M54 to M6 Link Road

TR010054

**8.8 LIU(L) Draft Statement of Common Ground with
The National Trust**

Version	Date	Status of Version
2 (P03)	3 November 2020	Issue to the ExA for Deadline 1

FIGURE 2.6
DRAFT ENVIRONMENTAL
MASTERPLAN
SHEET 4 OF 5

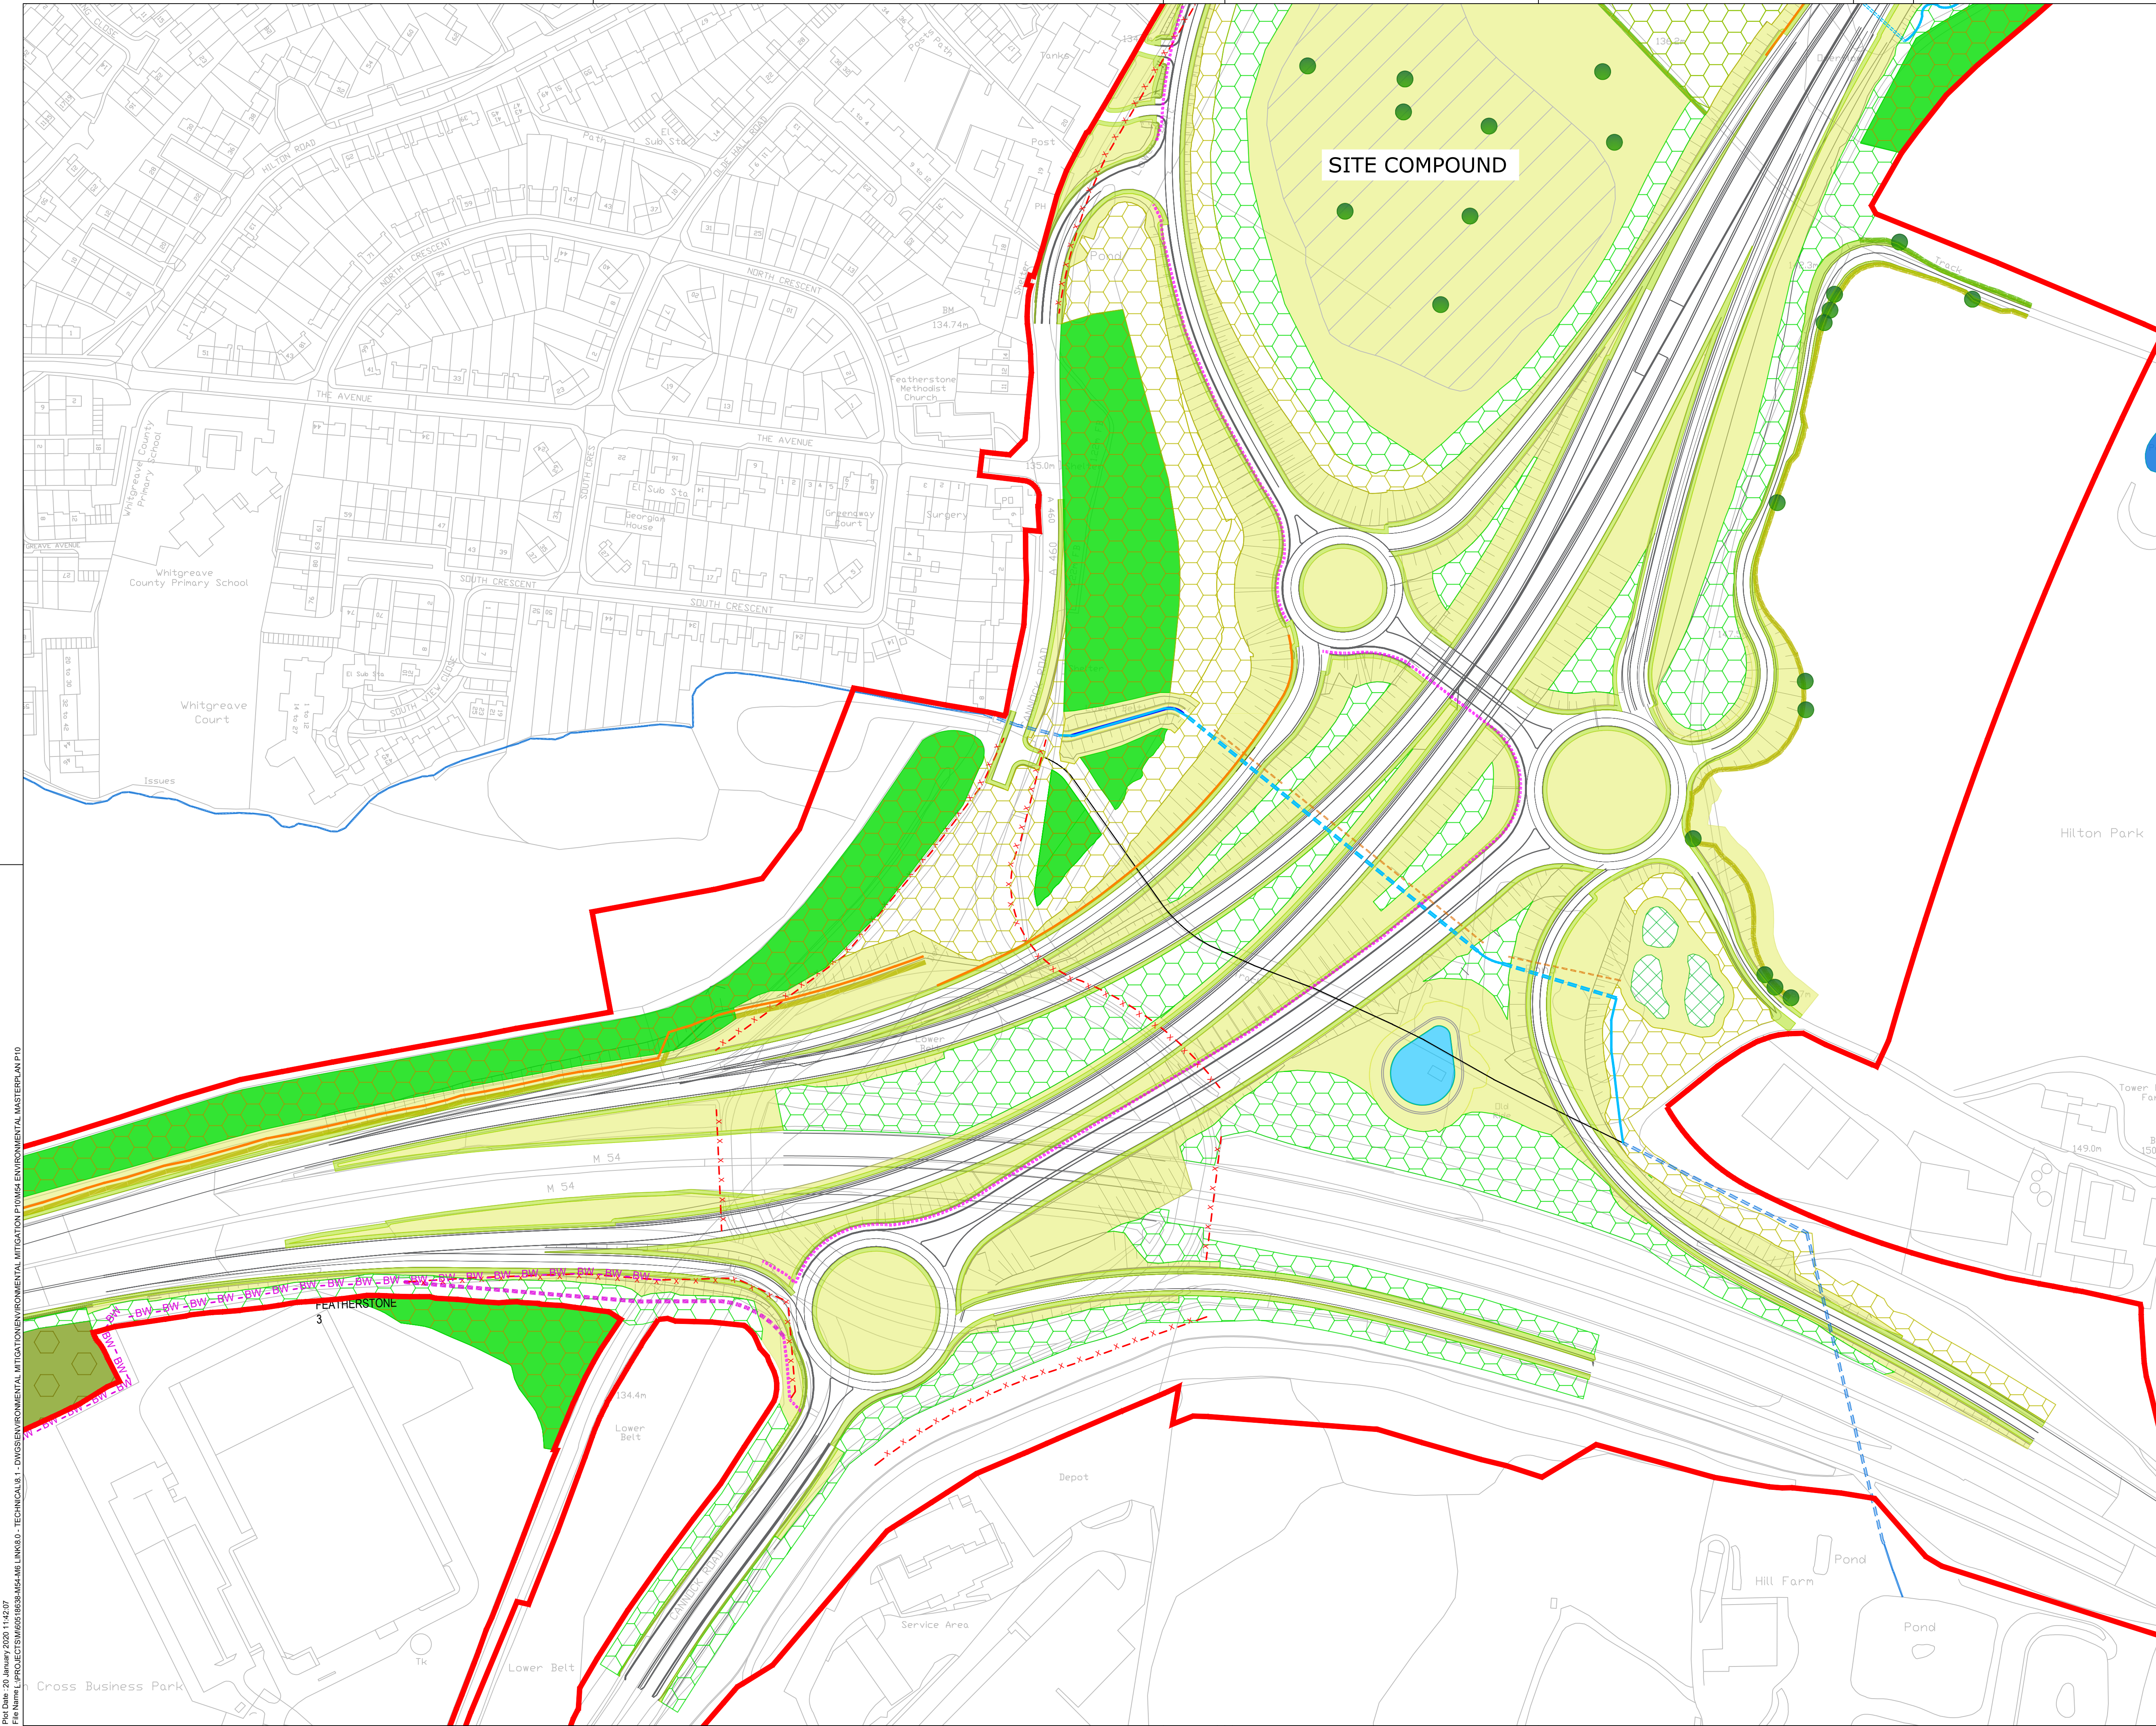
ES Chapter 8: Biodiversity [AS-025/6.1]						
Mitigation measures IR: NT-03	Section 8.8 'Design, mitigation and enhancement' Para. 8.8.3	NT [please confirm whether you] are content that the measures to mitigate the impacts on Whitgreaves Wood including compensation planting and improvement works to Whitgreaves Woodland are necessary to compensate for the impact on ancient woodland and that these measures are appropriately secured.	Highways England and the National Trust have a formal agreement relating to The M54 to M6 Link Road Development Consent Order and land at Whitgreaves Wood. This agreement allows Highways England to undertake these works within Whitgreaves Wood and ensures the National Trust will maintain these compensation measures. The measures required to compensate for the impact on	Under discussion	High	High
